Date: 13-Jun-2025  
Our Ref: 2025/91051

**Discharge of details reserved by conditions 4 (Acoustic Barrier), 5 (Noise Mitigation Scheme), 6 (Noise Control) on previous permission 2023/93486 for reconfiguration of building, re-orientation of car parking and service yard, erection of a noise barrier and external alterations  
Shawcross 170, Churwell Vale, Shawcross Business Park, Dewsbury, WF12 7RD  
Application Number: 2025/91051**

Figure 1 – Edward Architecture plan showing the required location of the Acoustic boundary fence (Plan Reference: 1111-EA-AP004B)

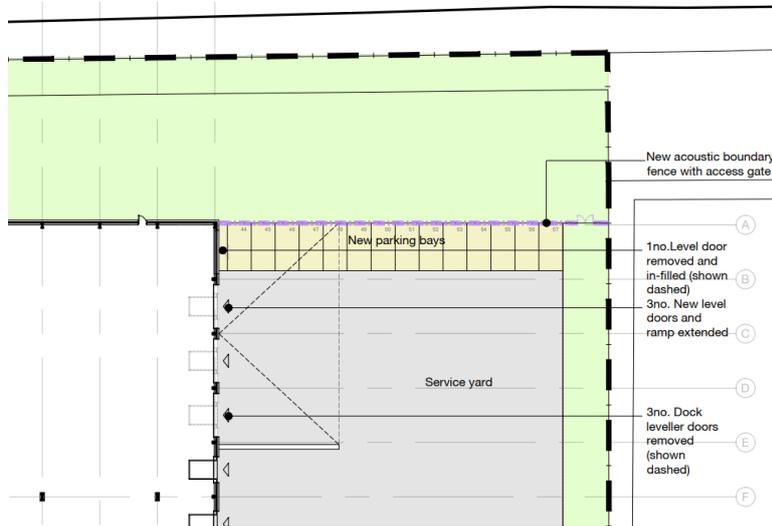
The document shows details of a 3m high timber fence which appears to be located in the same location as specified in figure 6 of the Noise Impact Assessment and provides photographs showing that this has been installed.

While the above is acknowledged, the information provided is not considered definitive to confirm whether the fence is fully in the correct location, nor to the correct specification, as required by condition.
